Recommendation Report for Planning Permission for Works or Extension to a Dwelling

REF NO: WA/92/18/HH

LOCATION: Lillypad
Yapton Lane
Walberton
BN18 0AR

PROPOSAL: Demolish existing conservatory, erection of single storey rear extension with balcony over and 2 No. new rooflights on south elevation.

C			
B			
A			
Client	Mr & Mrs Gormley		
Address	Lilly Pad, Yapton Lane, Walberton		
Drawing	EXTENSION & ALTERATIONS	No.	5418:1
Scale	1:50 1:100 1:250	Drawn	B
Date	OCT 18

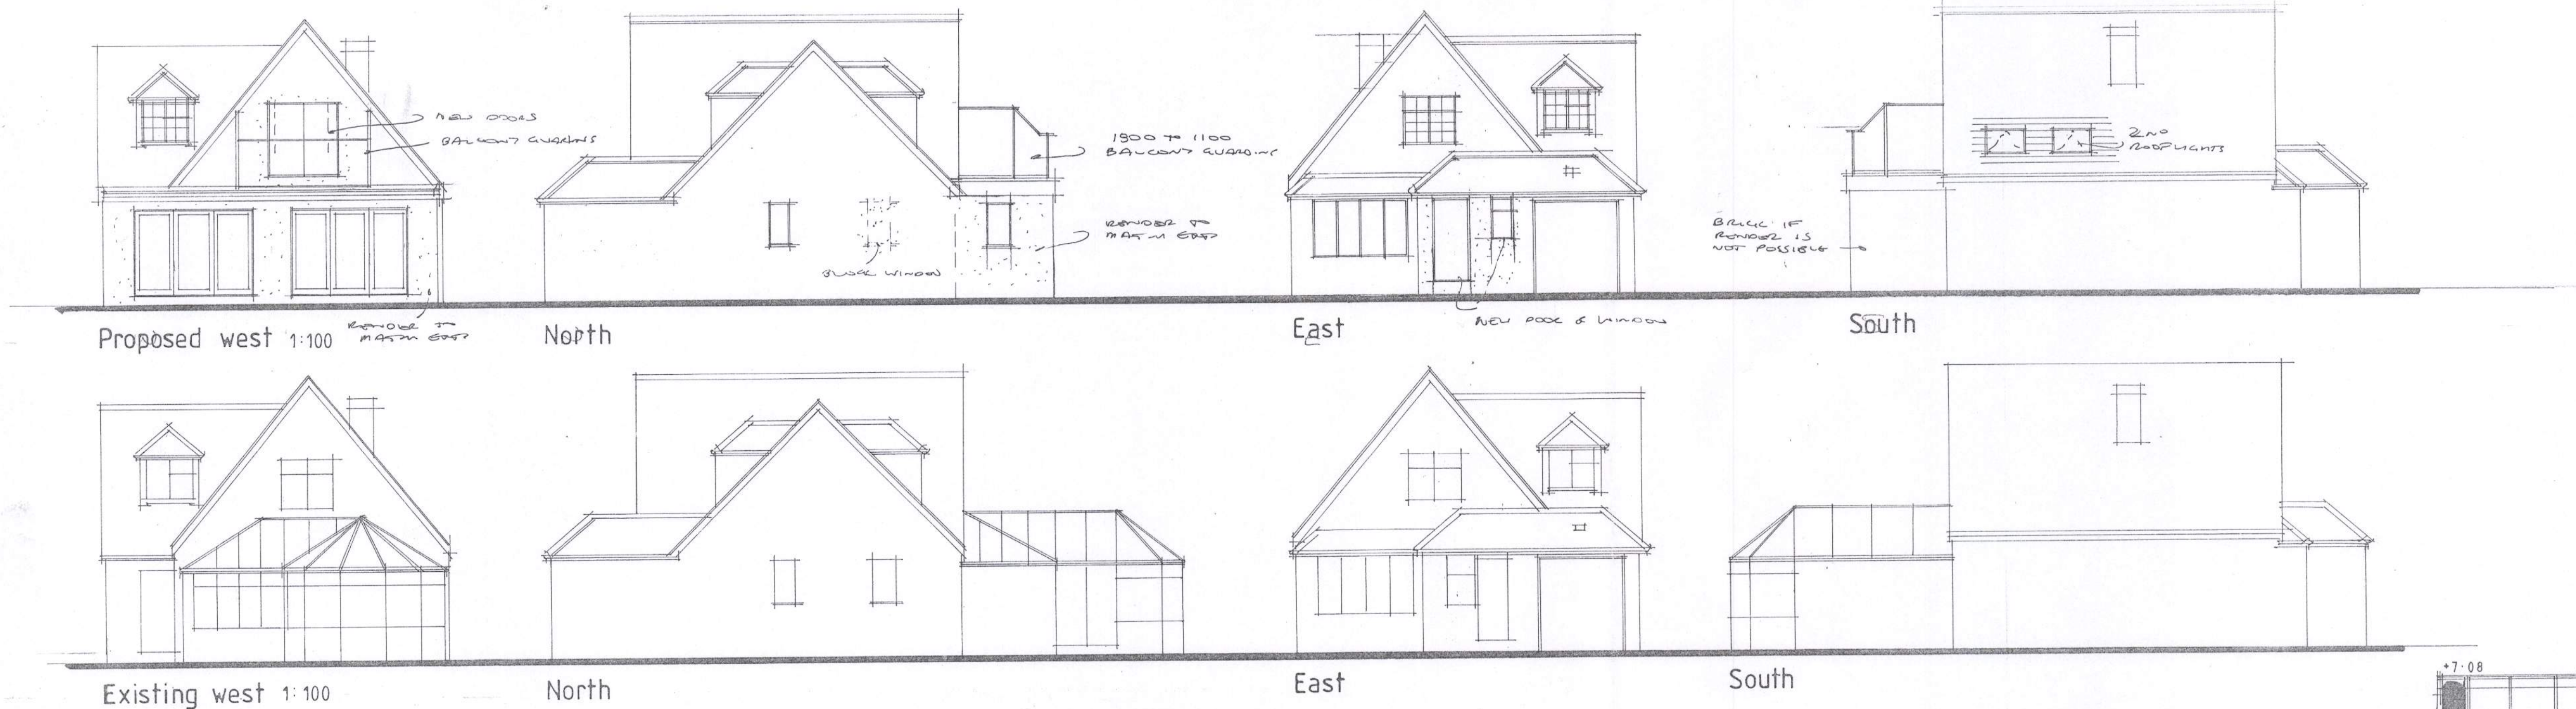
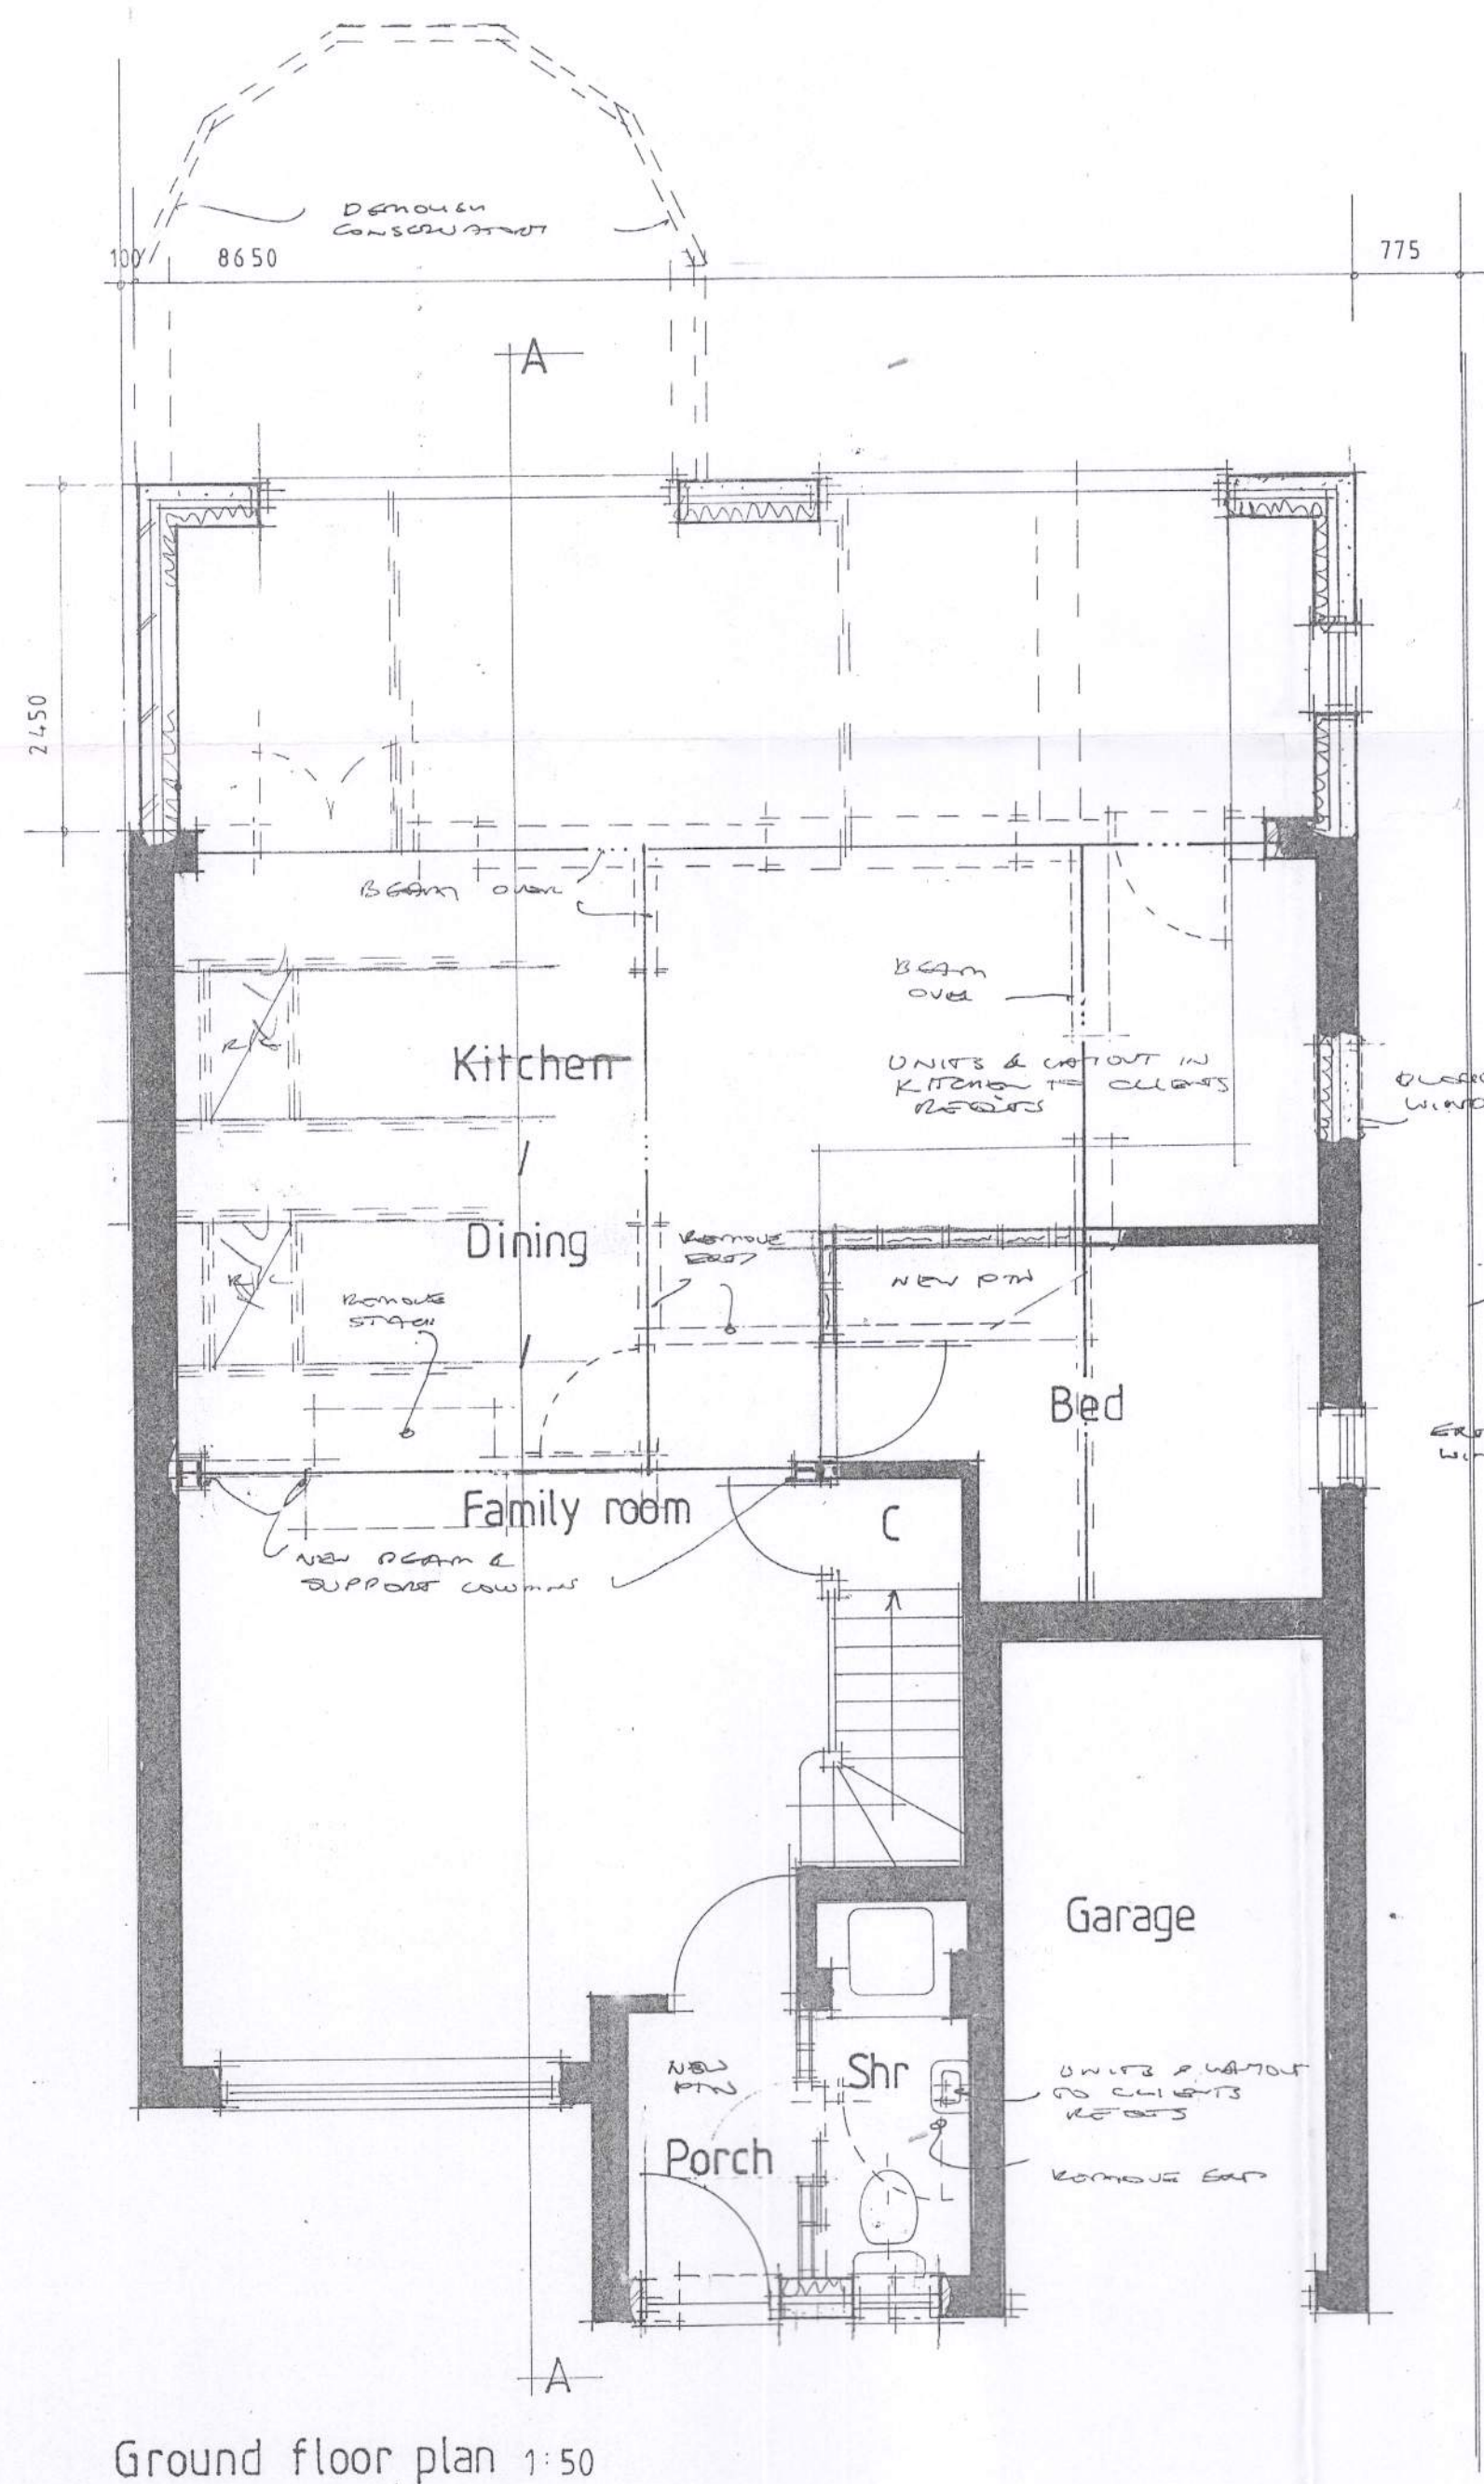
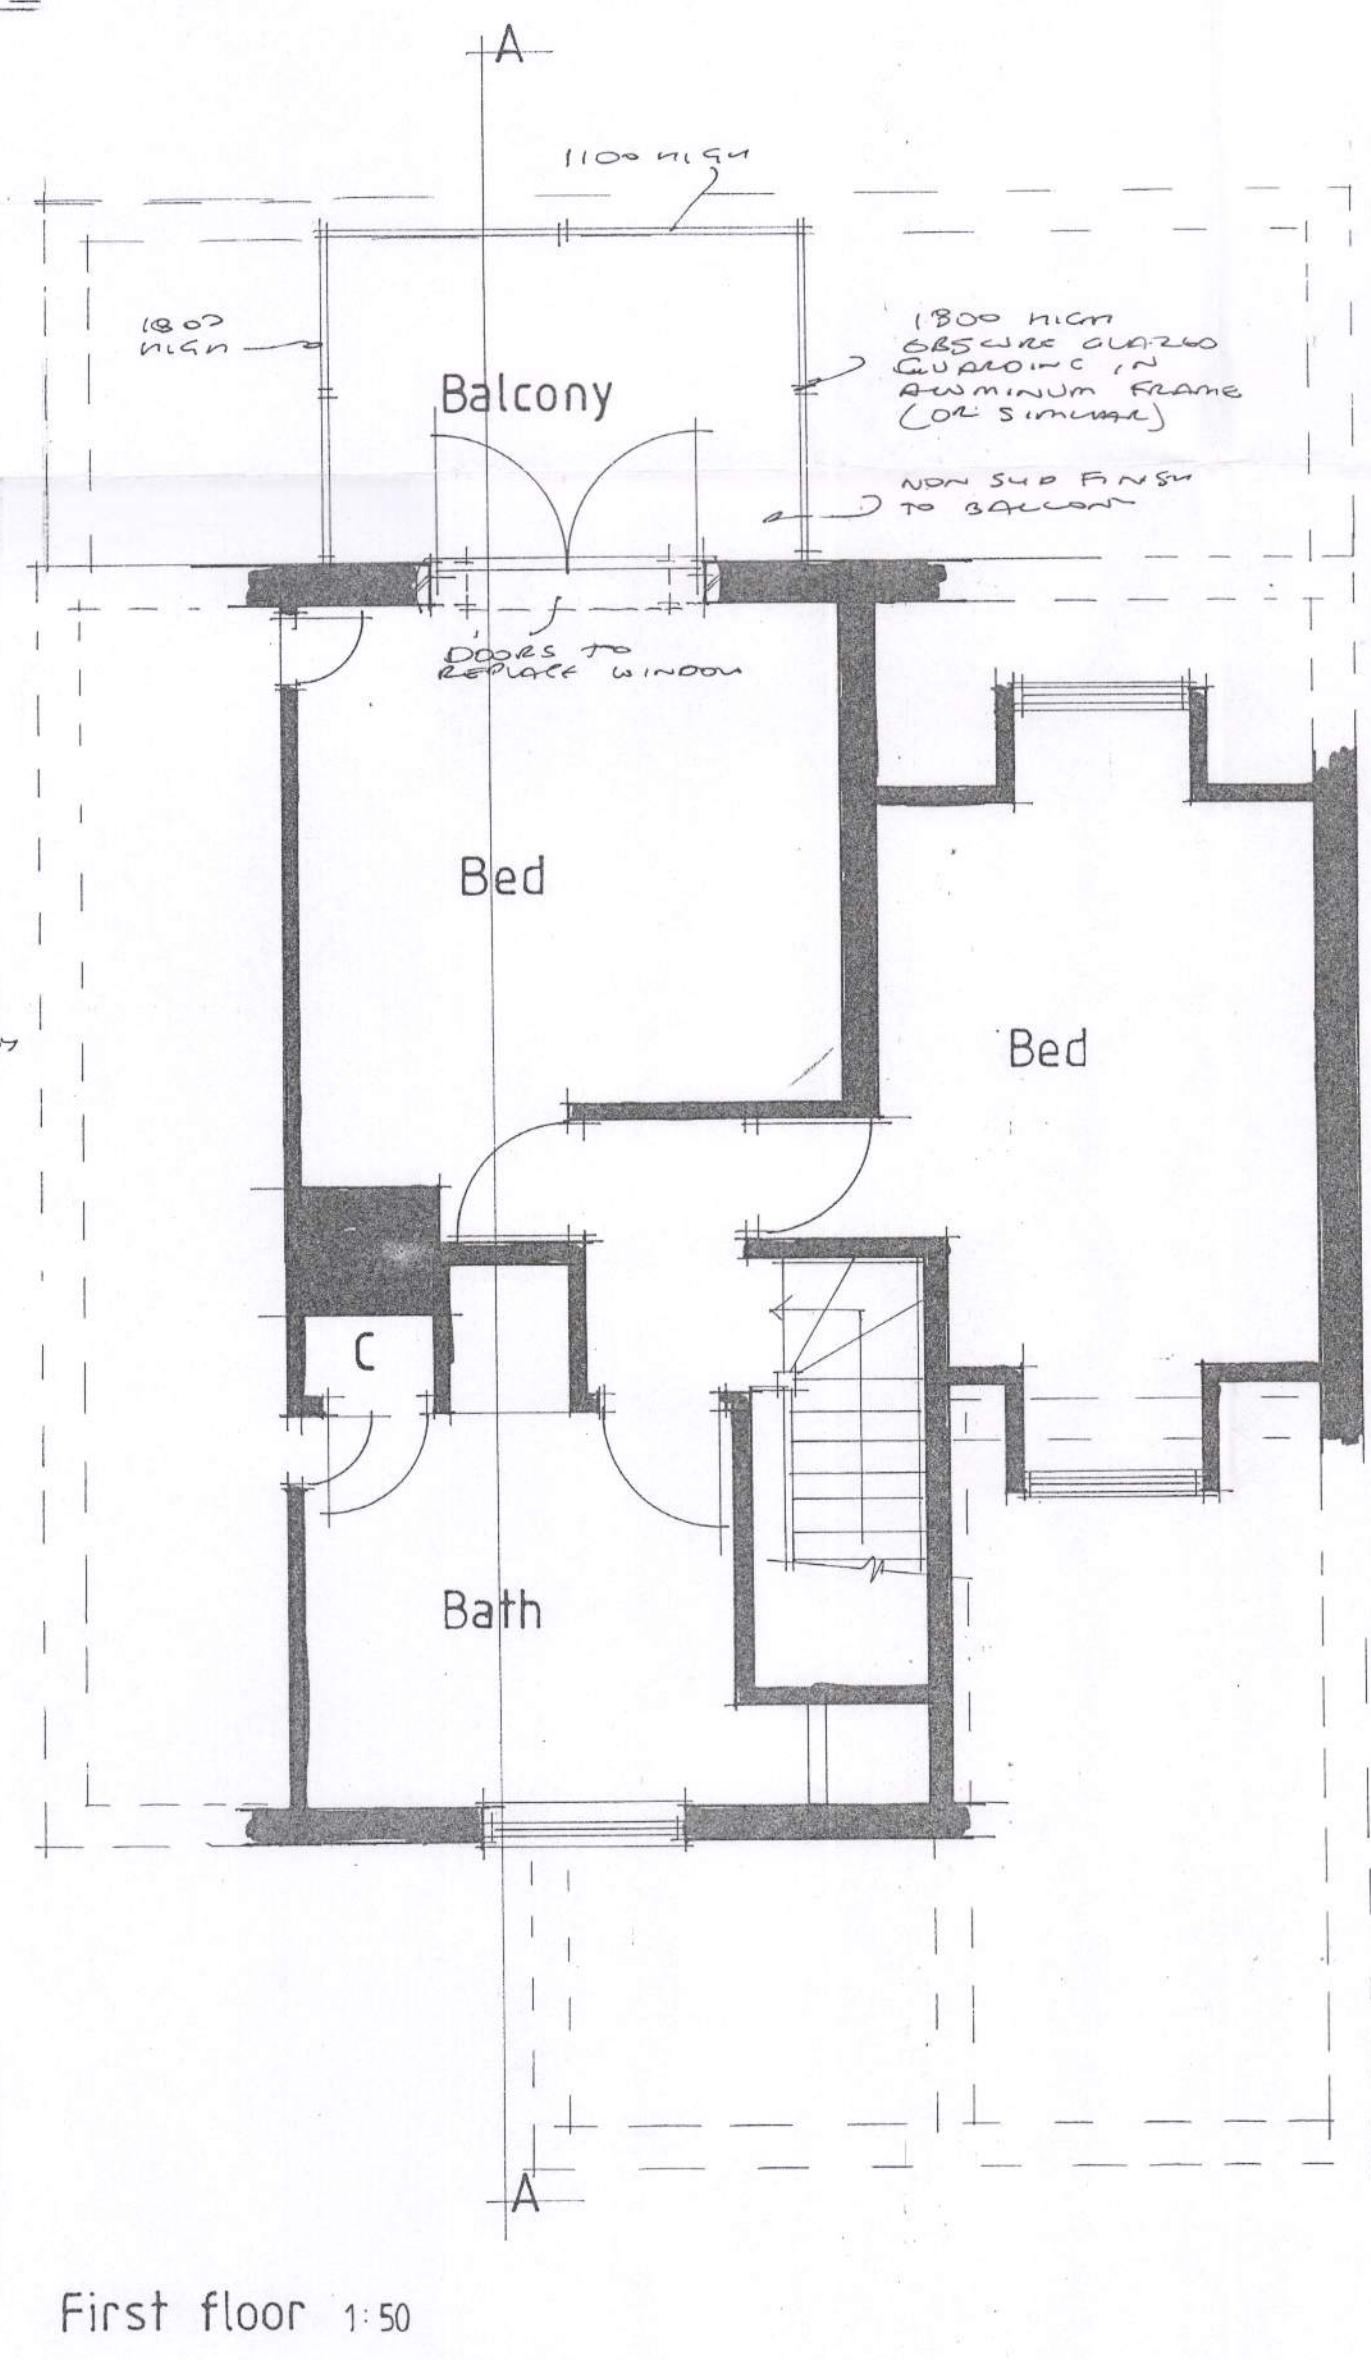
The balcony addition would create a raised platform, enclosed along its north and southern elevations by a 1.8m high obscure glazed screen. By virtue of the current outlook from upper floor windows, the precedence set by the balcony serving the rear of Stafford Cottage to the North. On balance a raised platform with obscured glazing is considered acceptable and would not be significantly detrimental to the impact on the neighbouring residential amenities of adjacent occupiers. The balcony is therefore permitted subject to condition for the retention of obscure glazing to the balcony.

- 4 The obscure screening shown on the submitted plans shall be installed prior to the first use of the balcony and be retained thereafter in perpetuity.
